**Memorandum
Department of Planning and Development
Planning Division**

Re: Ocean Gateway Marine Passenger Facility
State of Maine Department of Transportation and City of Portland,
Applicants

TERMINAL BUILDING
EXTERIOR ELEVATIONS

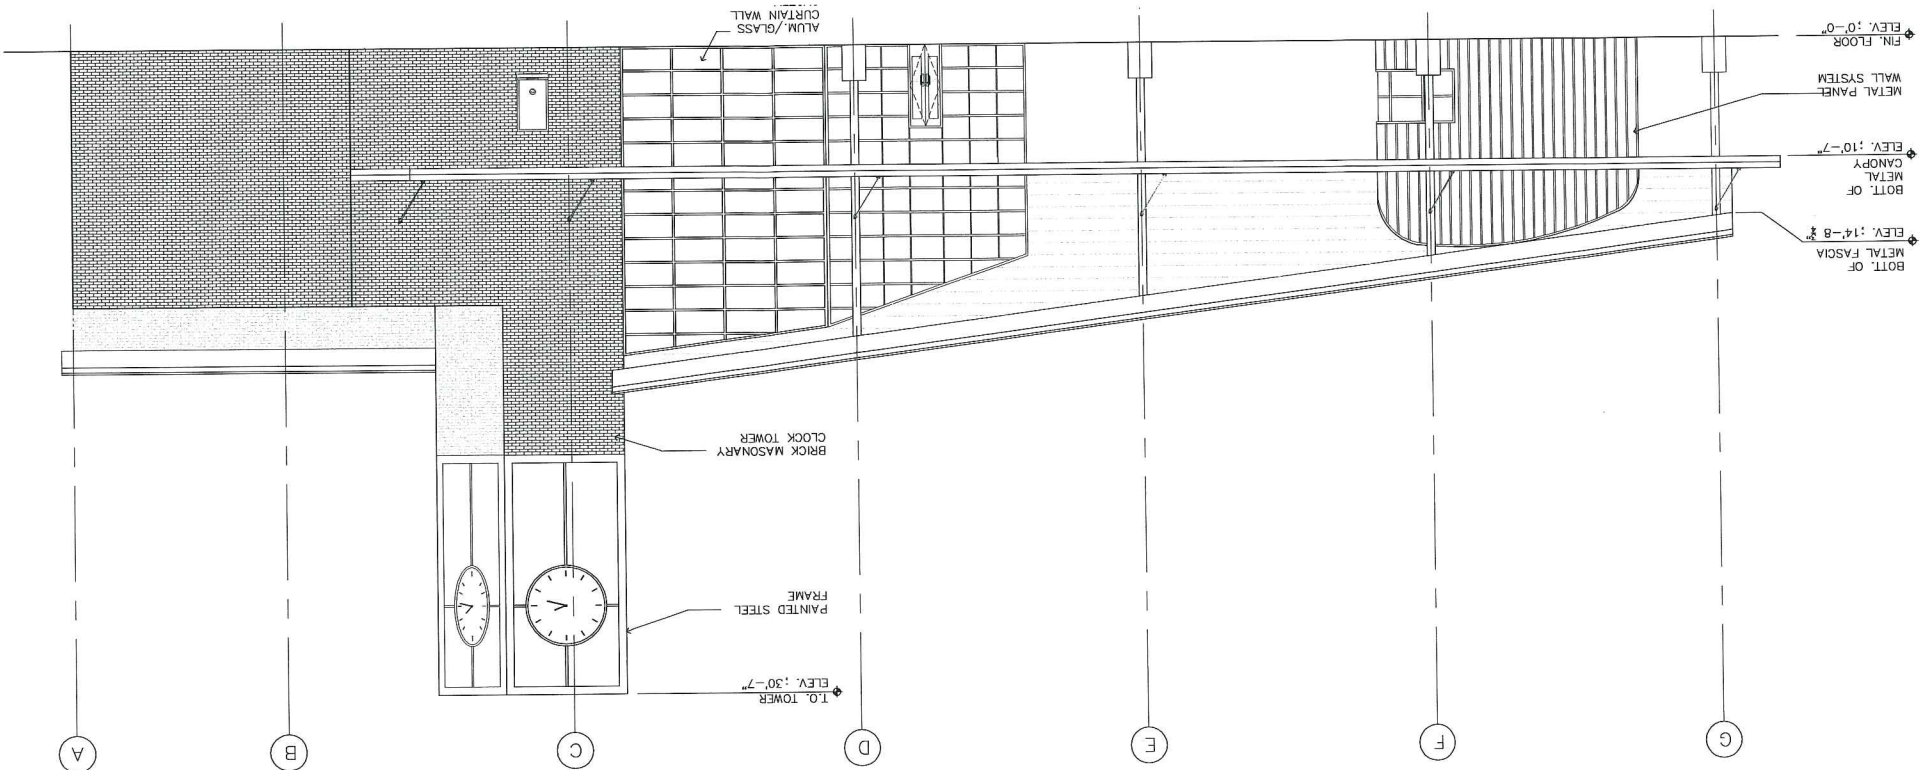
The Board should note that the project is also subject to the Flood Plain ordinance. In this area the flood plain regulation may require a significant (+/-3 feet) change in elevation in the structure of the terminal building. The project team is currently evaluating approaches to address these issues and Staff anticipates a Flood Plain narrative for review prior to Public Hearing. The Board may want to discuss the potential impacts of these changes with the project team at the workshop.

CITY OF PORTLAND
OCEAN GATEWAY PHASE 1
RECEIVING STATION
EXTERIOR ELEVATIONS

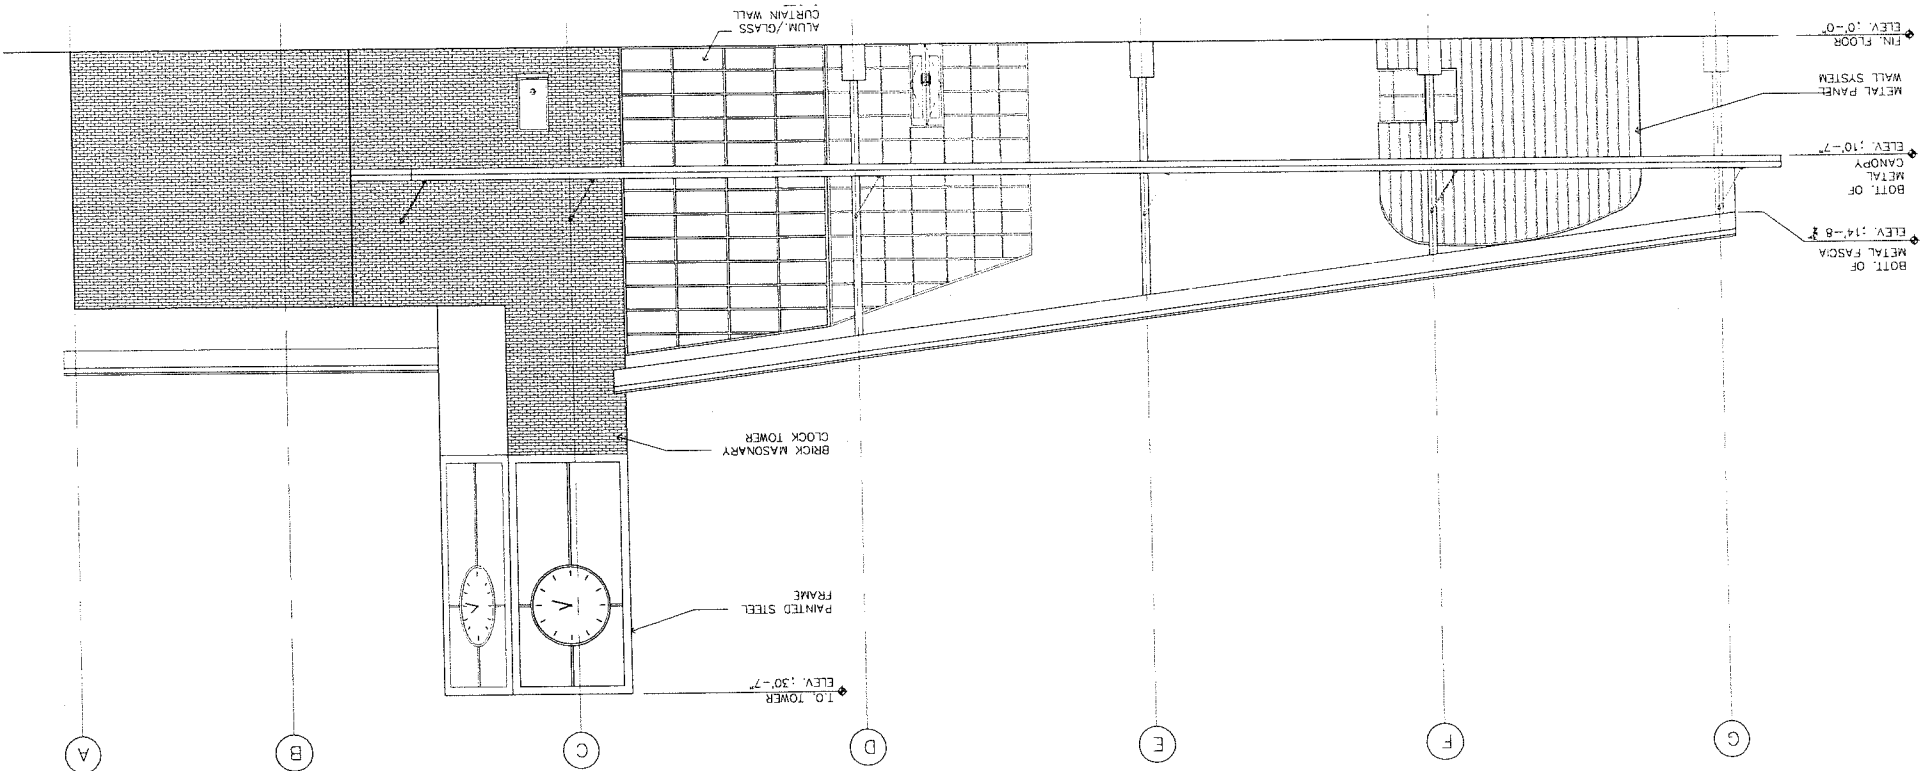
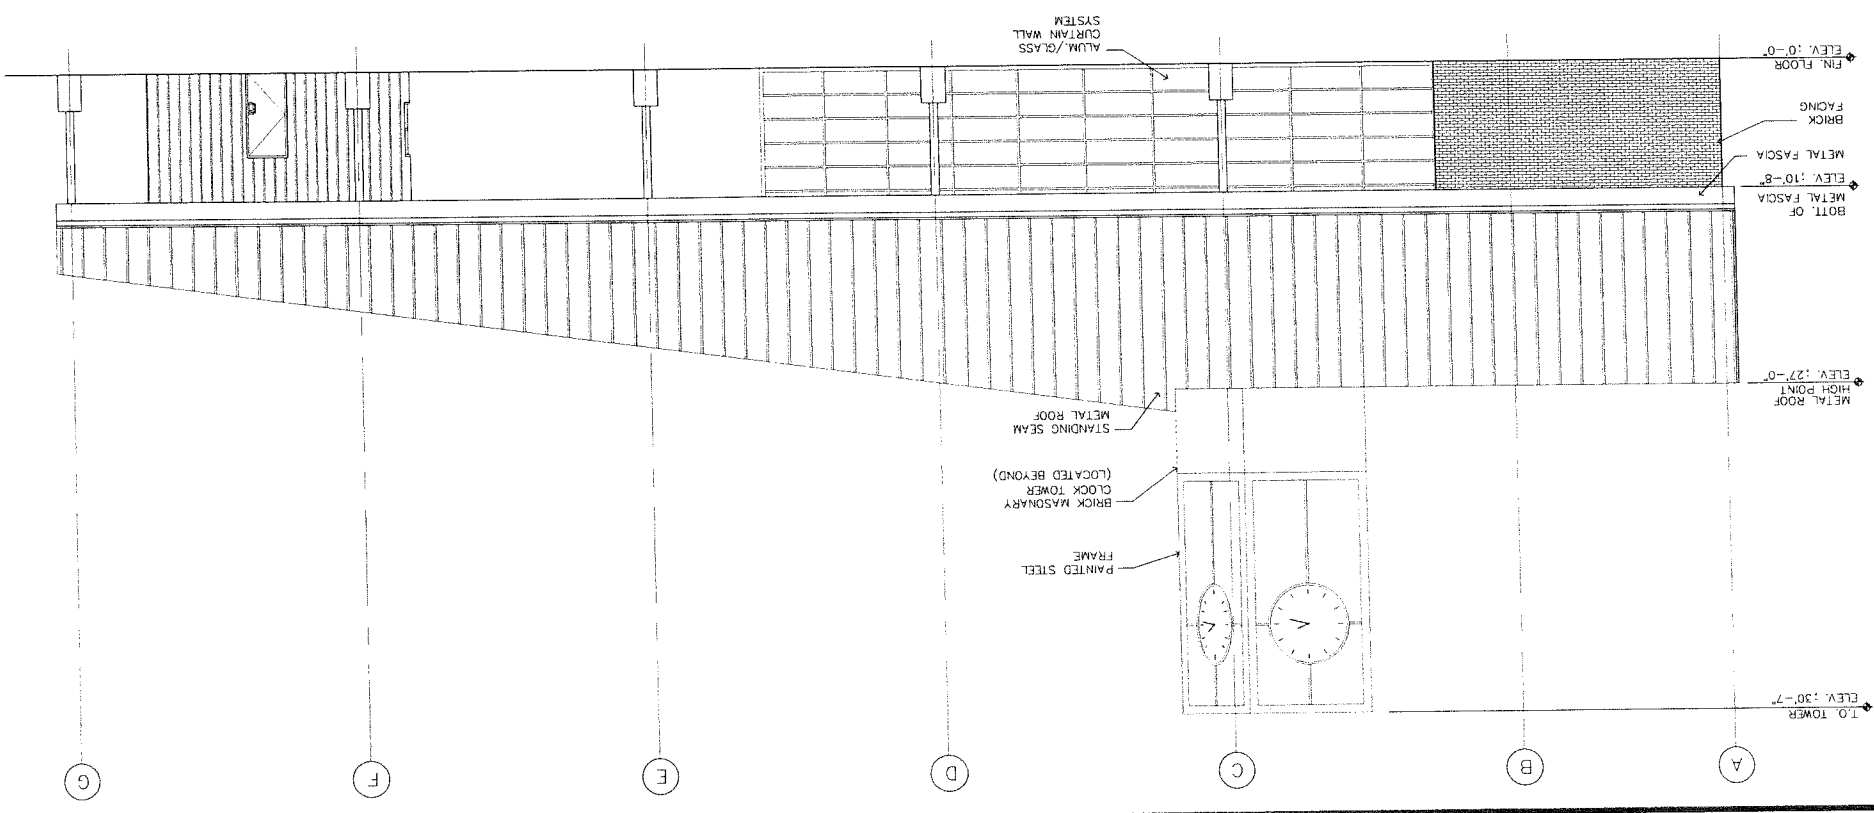
The design of the receiving station has generated discussion regarding its orientation to the downtown. The project design team continues to work with the design to provide a more welcoming and interesting view of the structure from Commercial Street and the Old Port.

CITY OF PORTLAND
OCEAN GATEWAY PHASE 1
POST-DEVELOPMENT
STORMWATER PLAN

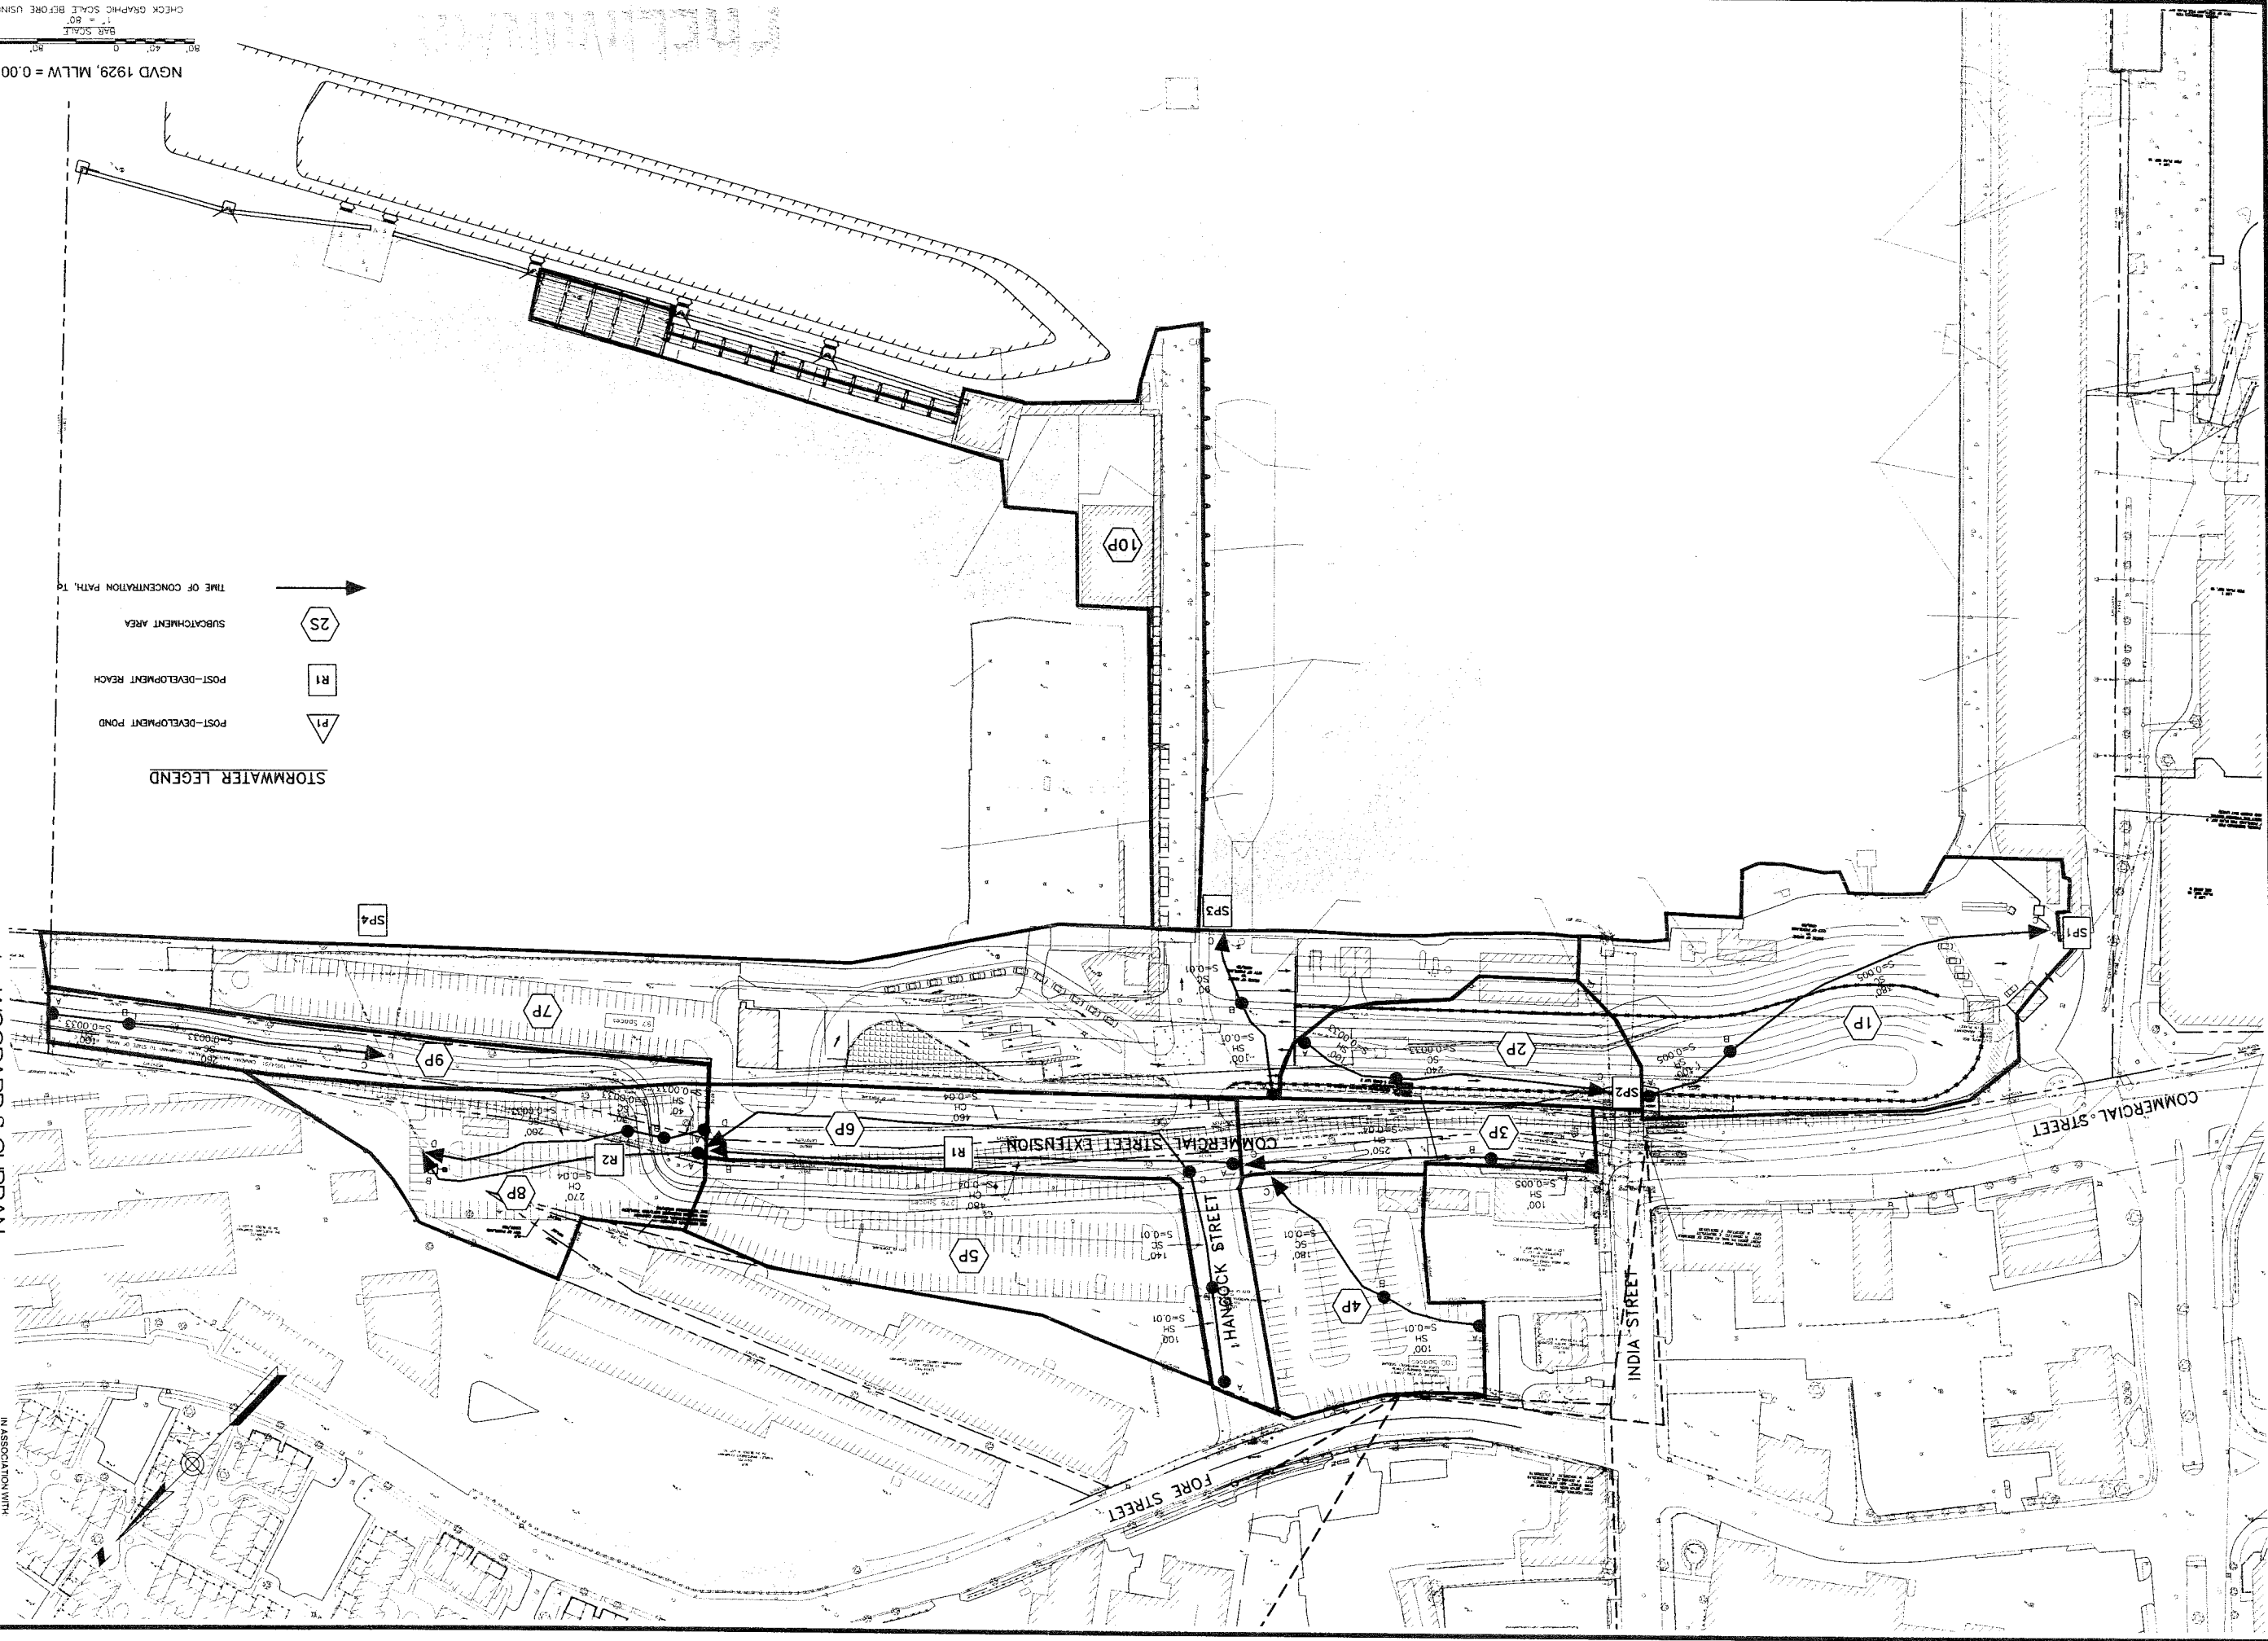
The stormwater management plan has been revised since the previous memo. The new management plan is included under tab 6 in the project binder. The plan provides more stormwater quality treatment and is anticipated to achieve a 40% total suspended sediment removal rate for the site. This level achieves the quality looked for by the State as part of the Site Location review for the project.

DRC Jim Seymour is continuing to review the stormwater design and has found that the plan is approaching an approvable level of specificity and performance. He suggests that the applicant provide better collection in areas where stormwater needs to travel significant distances to reach catch basins and he suggests that the primary queuing and circulation areas be finished with a topcoat of new pavement. Currently, the project is proposing to "cut and patch" existing pavement within the BIW site. A detailed memo will be provided.
